October 18, 2016

Re: Winnelson Wake House Remodel Addition
3545 Princeton Dr NE
Traffic Circulation Layout
Architect's Stamp 09-26-16 (G16D152)

TCL PLAN  
REVISED 11.11.2016

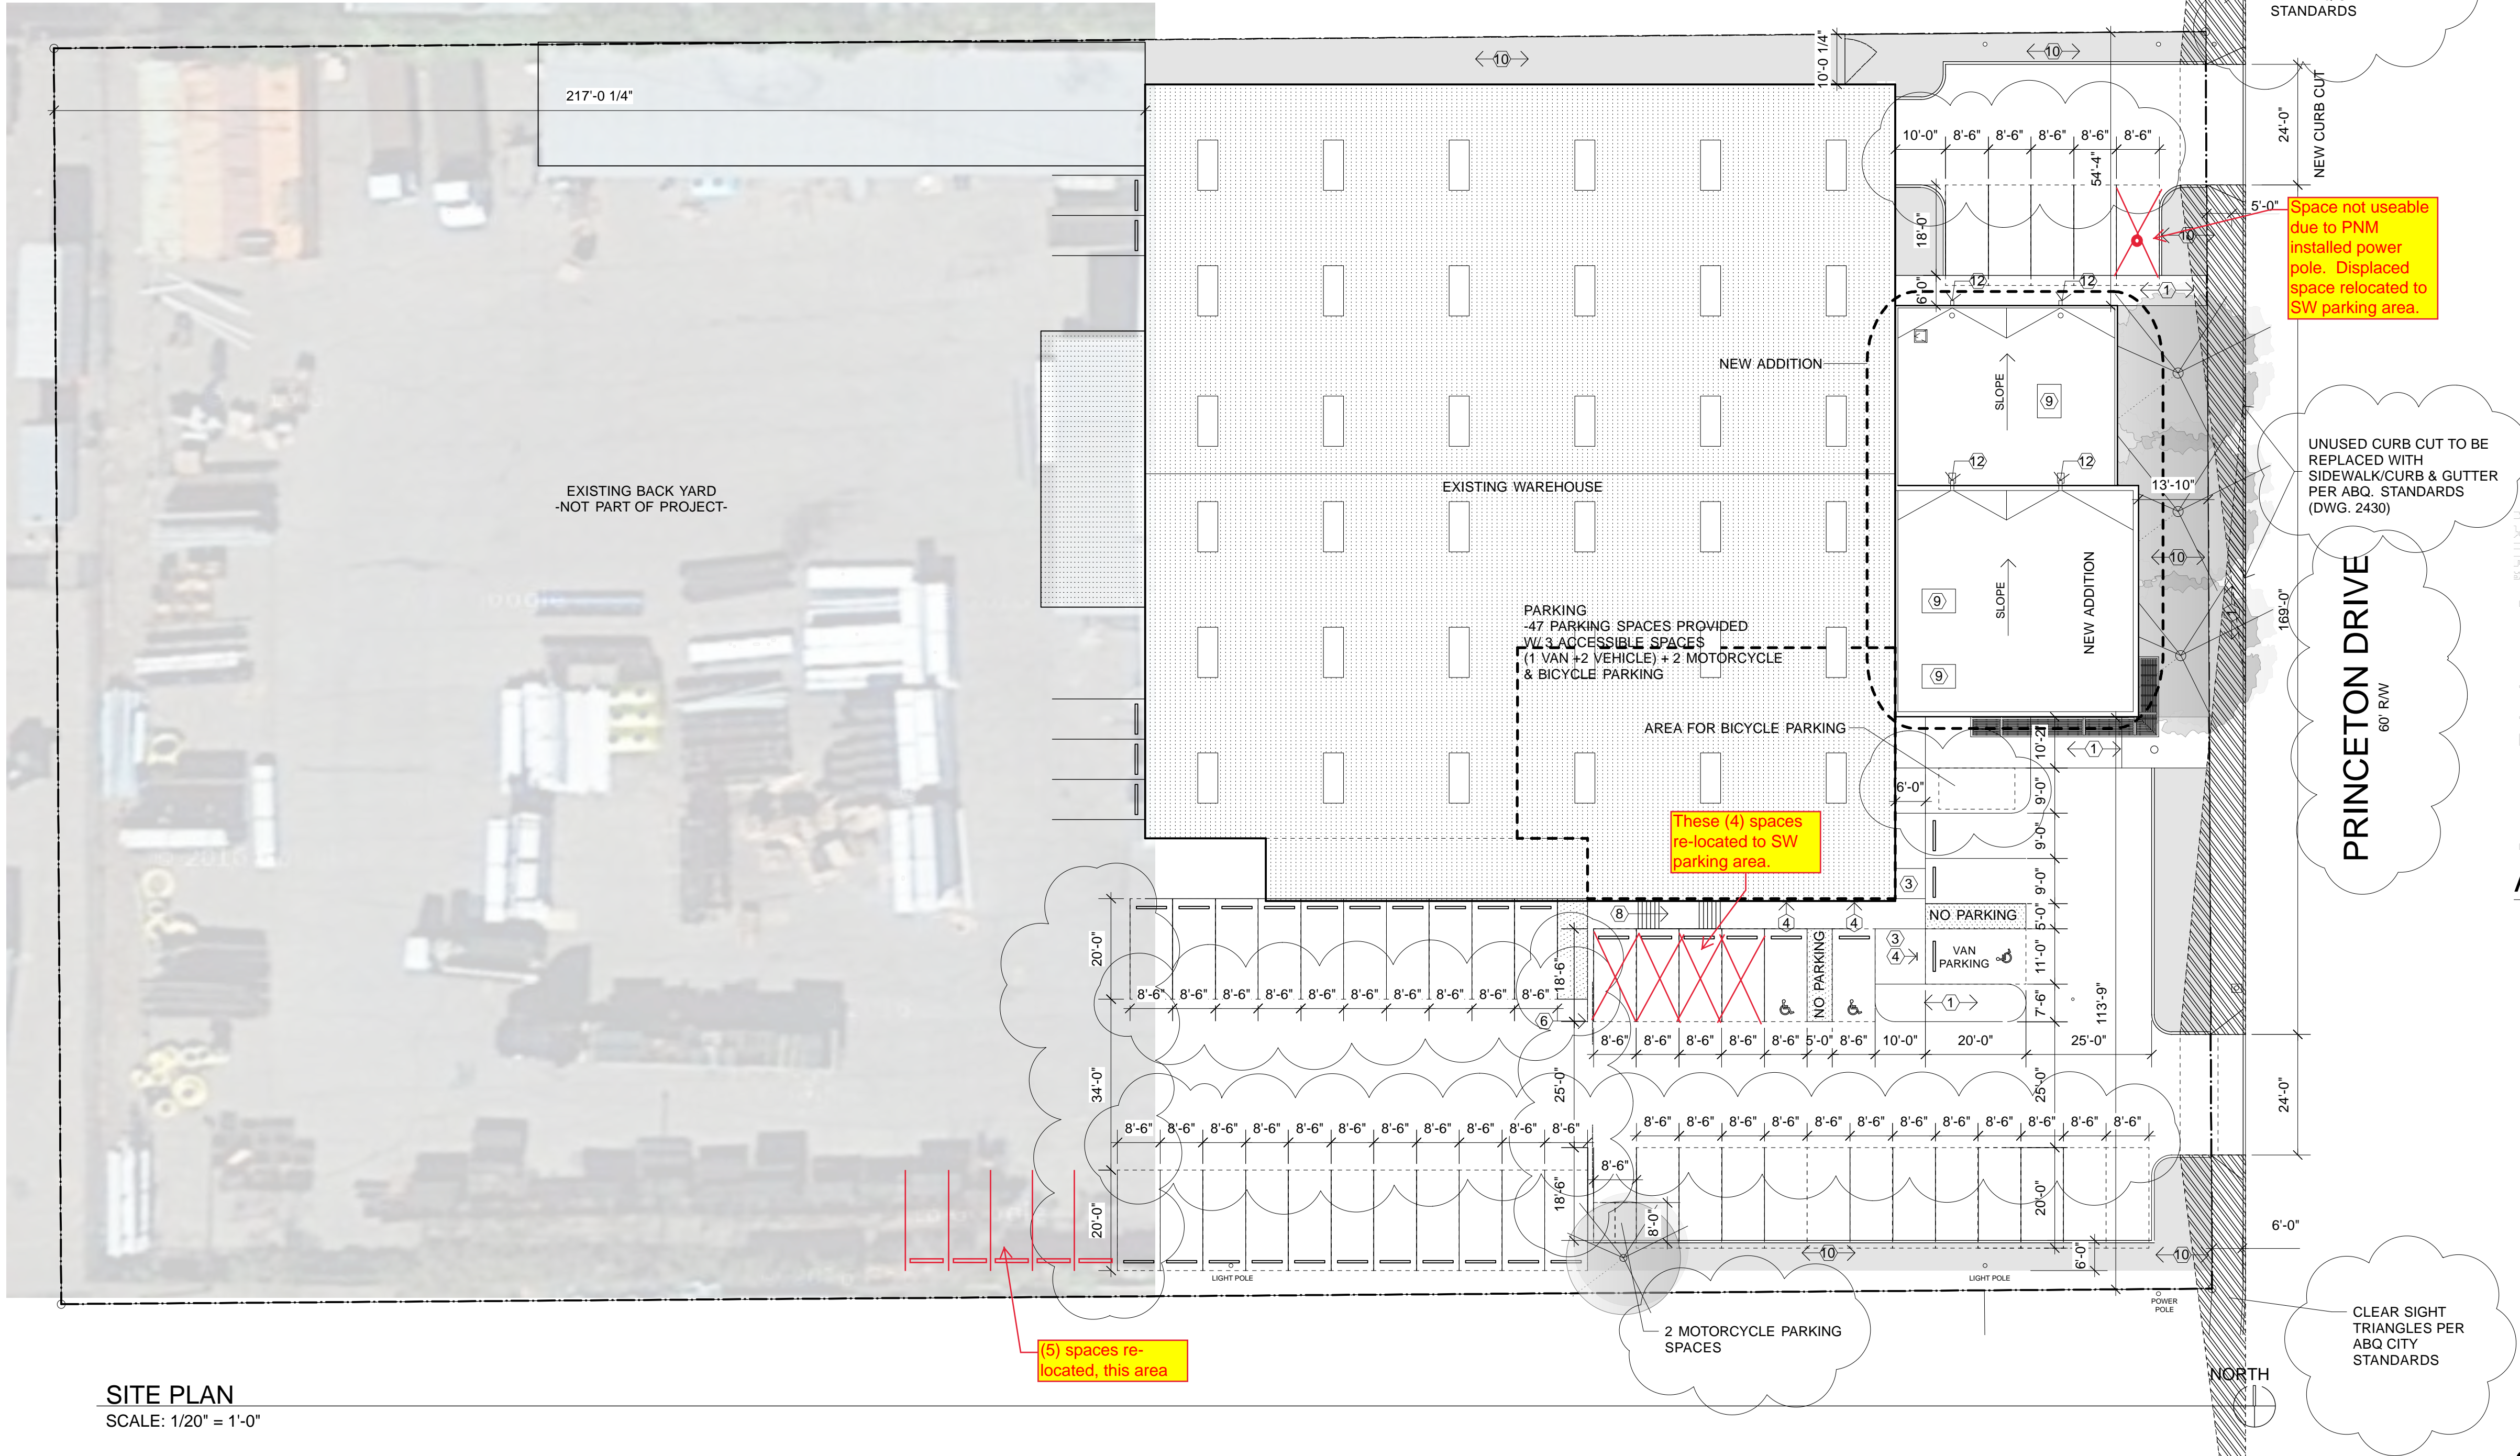
1. Identify the right of way width and label on Princeton Dr NE.
2. Please list the width and length for all existing and proposed parking spaces. Some dimensions are not shown.

3. The ADA access aisles shall have the words **"NO PARKING"** in capital letters, each of which shall be at least one foot high and at least two inches wide, placed at the rear of the parking space so as to be close to where an adjacent vehicle's rear tire would be placed. (66-1-4.1.B NMSA 1978)

4. A 5 ft. keyway is required for dead-end parking aisles.
5. Per DPM, a 6 ft. wide ADA accessible pedestrian pathway is required from the HC parking stall access aisles to the building entrances. Please clearly show this pathway and provide details.

6. Call out where motorcycle parking and bicycle parking is located on site plan.
7. All sidewalks along streets should be placed at the property line.
8. Show the clear sight triangle and add the following note to the plan:
"Landscaping and signage will not interfere with clear sight requirements. Therefore, signs, walls, trees, and shrubbery between 3 and 8 feet tall (as measured from the gutter pan) will not be acceptable in the clear sight triangle.

9. Unused curb cuts must be replaced with sidewalk and curb & gutter. A build note must be provided referring to the appropriate City Standard drawing.
